Subject: FW: Planning Consultation on: A/234/21/DOC

Application ref: A/234/21/DOC

Description: Approval of details reserved by condition imposed under A/125/13/ relating to condition 17-landscape scheme

Location: Chandlers BMW Worthing Manor Retail Park Rustington BN163FH

scheme: Mill Lane Site
client: Group 1 Automotive
drawing: Landscape Re-planting
date: October 2021
scale: 1:200@A1
drawing no: STORE18832 30 Sheet 1
drawn: LS checked: DKM

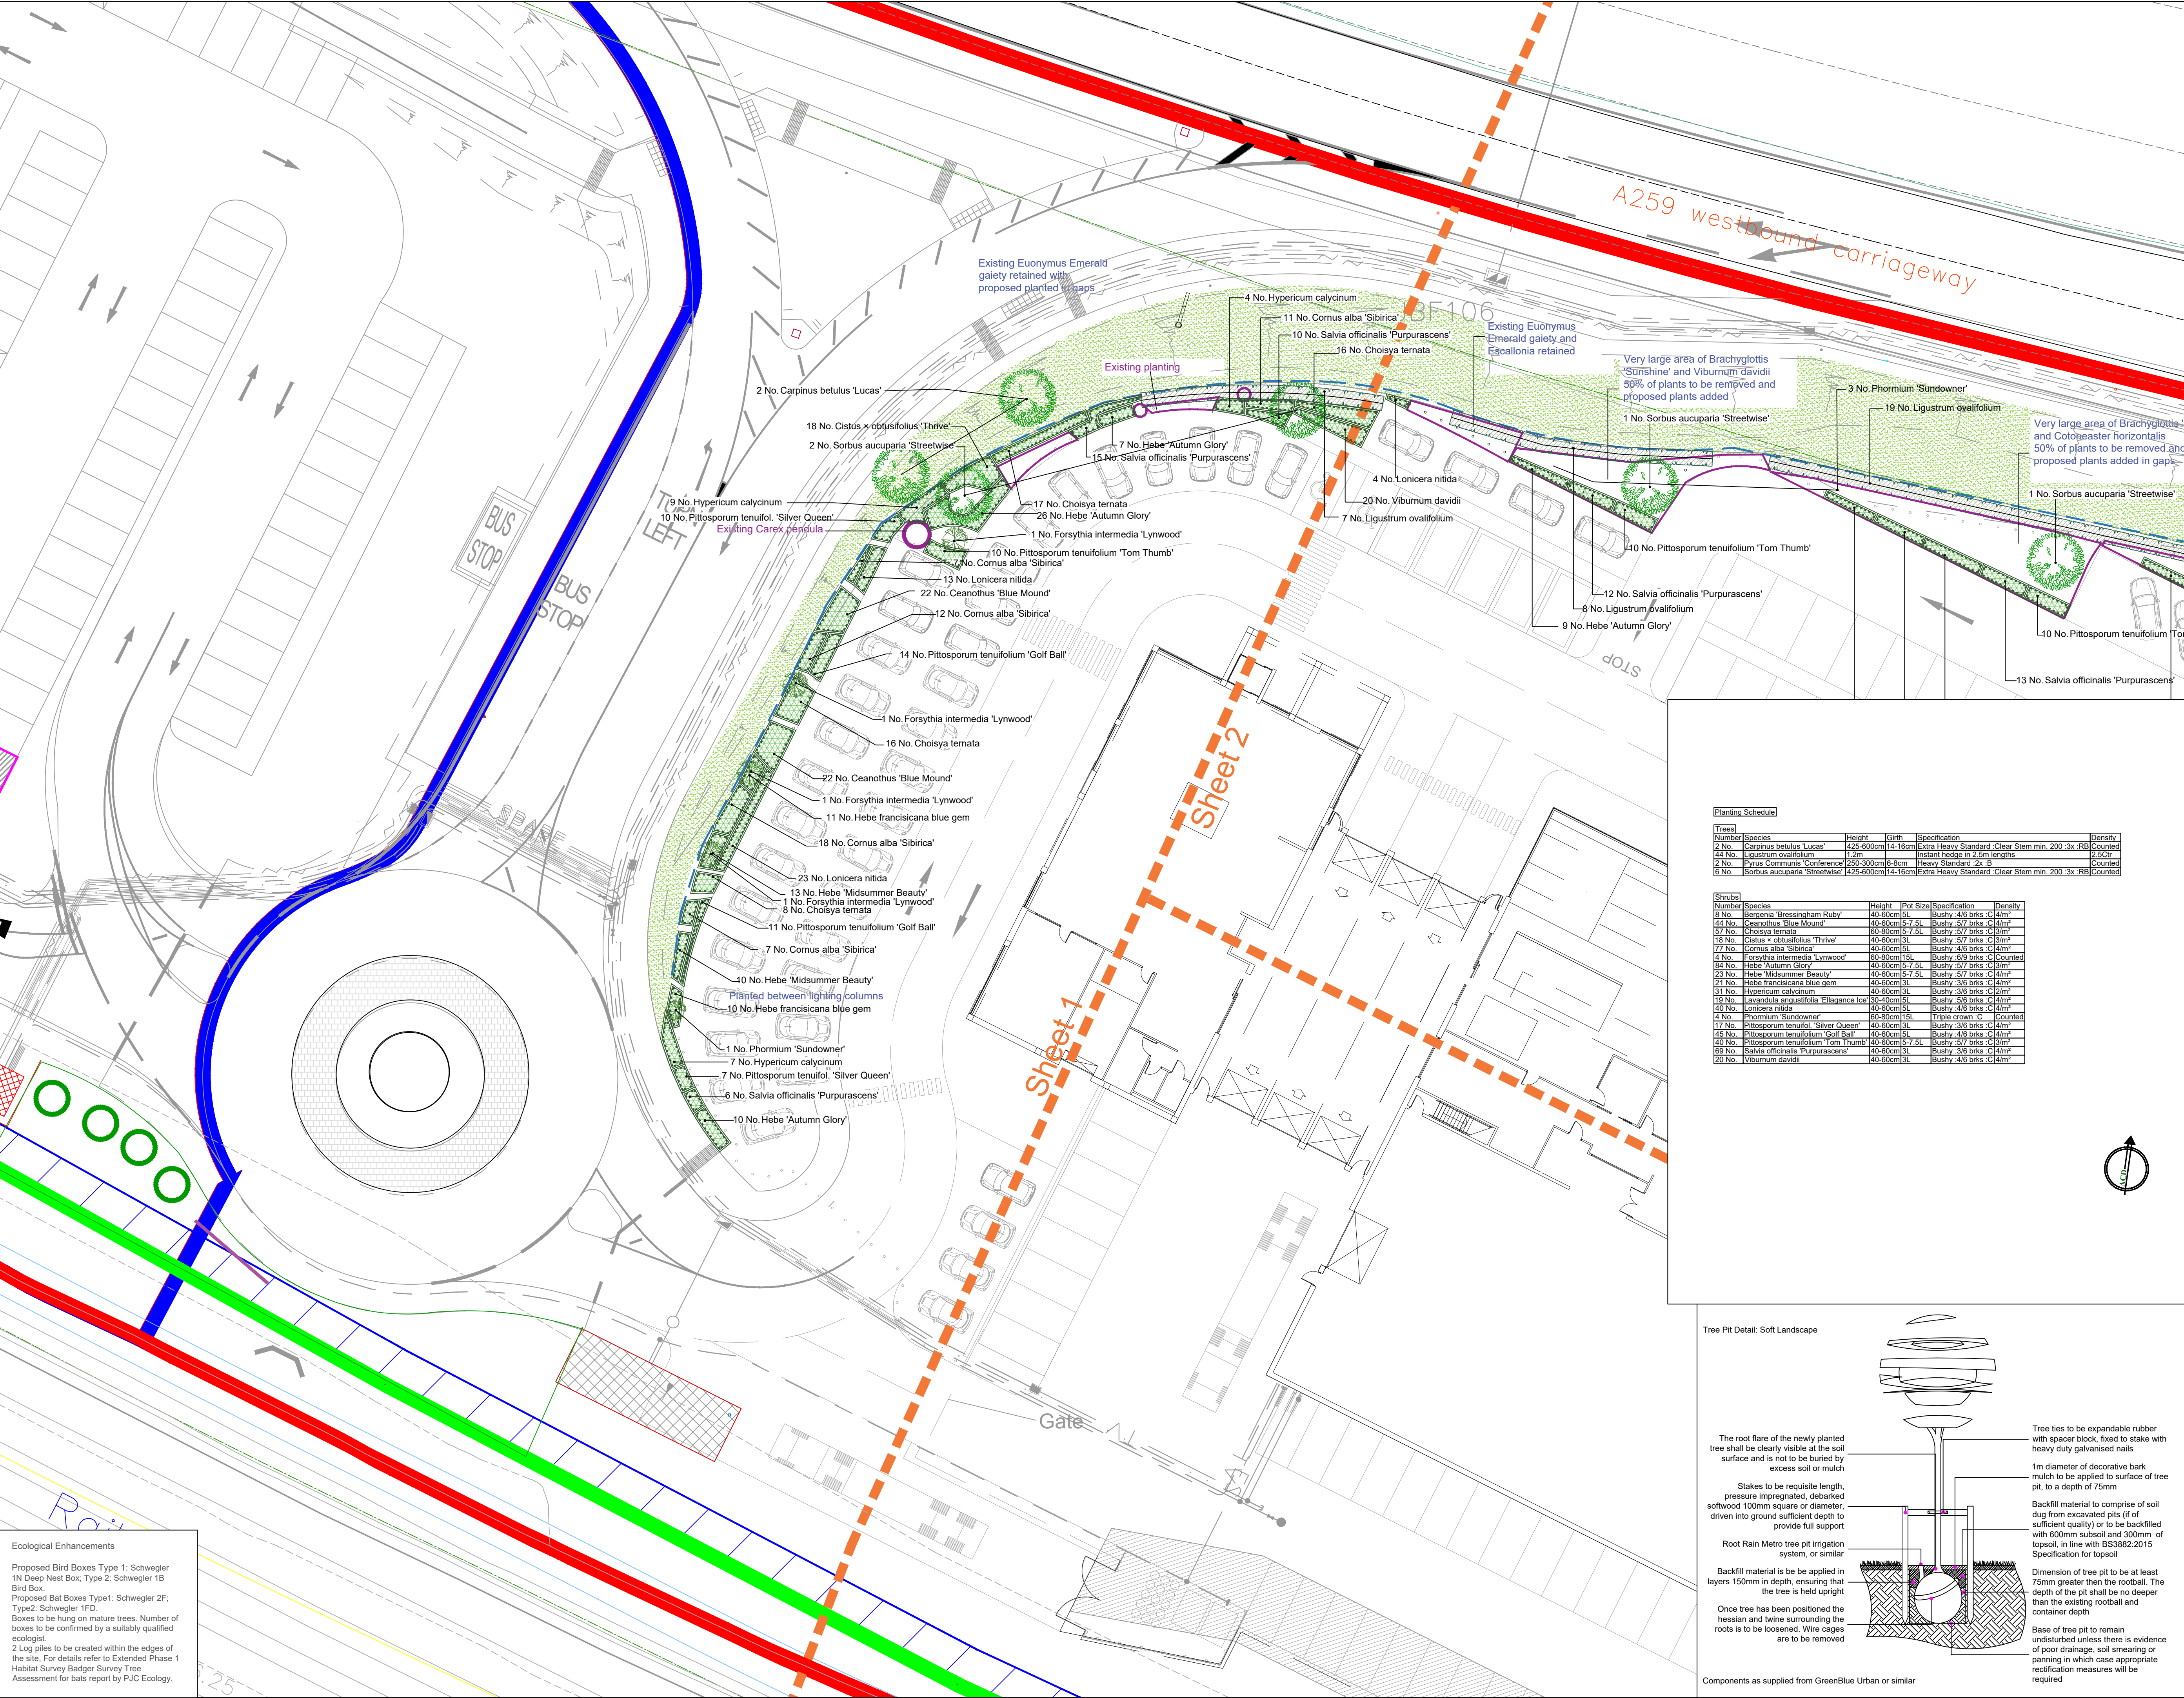
Landscape Re-Planting Dwg No STORE18832 20 Sheet 1 and Re-Planting Dwg No STORE18832 20 Sheet 2 has now indicated a total of 10no trees to the north and western aspects of the building frontage. Only 5no size 14-16cm girth to the frontage with 3no 14-16 to the western area and 2no further size 6-8 cm girth to the eastern frontage.

These specified trees are still inadequate in quantity, location and specified size and have failed to address the proposed outline scheme previously submitted and still fails to address the mitigation for trees removed and the screening requirement on this section of the development parcel.

44no *Ligustrum ovalifolium* are also listed under trees for this frontage area, these are misleading as these are not trees (in any screening sense) but hedging proposed at an install and maintenance height of 1.2m and which will do nothing to add softening or screening to this frontage and minimal biodiversity benefit to this location.

The large hardstanding vehicle parking areas have not received any landscape consideration or proposal (devoid of any tree planting proposals) and which still contradicts that shown at outline.

The previous application A/157/21/DOC indicated minimal and inadequate tree planting (6no std Birch 10-12cm) also to the rear of the building these appear to have now been omitted entirely from these proposals, this area also needs to be addressed and included within the proposal for the site.

Areas of existing groundcover mono block shrub planting along the site frontage have been proposed for removal and the introduction of a wider variety of shrub species introduced is seen as an improvement, however these still remain largely low growing species which again whilst improving biodiversity habitat will not add to the screening or softening of the building. The introduction of mid height shrubs and shrubby tree species need to be provided particularly along the western access road section.

The revised scheme re-submitted under this application A/234/21/DOC in Re-Planting Dwg No STORE18832 20 Sheet 1 and Re-Planting Dwg No STORE18832 20 Sheet 2 remains in contradiction to the detail shown under Landscape Proposals Store 18832 14A dwg and still proposes a poor and inadequate landscape scheme for this site and location. This is particularly in reference to the inadequate proposed tree planting proposals which still fail to represent the detail which was provided within the approved application and which still fail to enhance and soften the site, fitting the location and in keeping with the adjacent scheme to the west of this site.

These revised proposals have provided insufficient trees in quantity and specification and have failed to take into account that the tree sizes need to be specified at a size which represents the loss of growth potential since the building was completed exceeding the EHS Extra heavy size specification.

Recommendation to not approve the details reserved by condition imposed under A/125/13/ relating to condition 17-landscape scheme until a suitable landscape scheme with particular emphasis on the tree proposals and specification has been approved and time frame for implementation agreed.
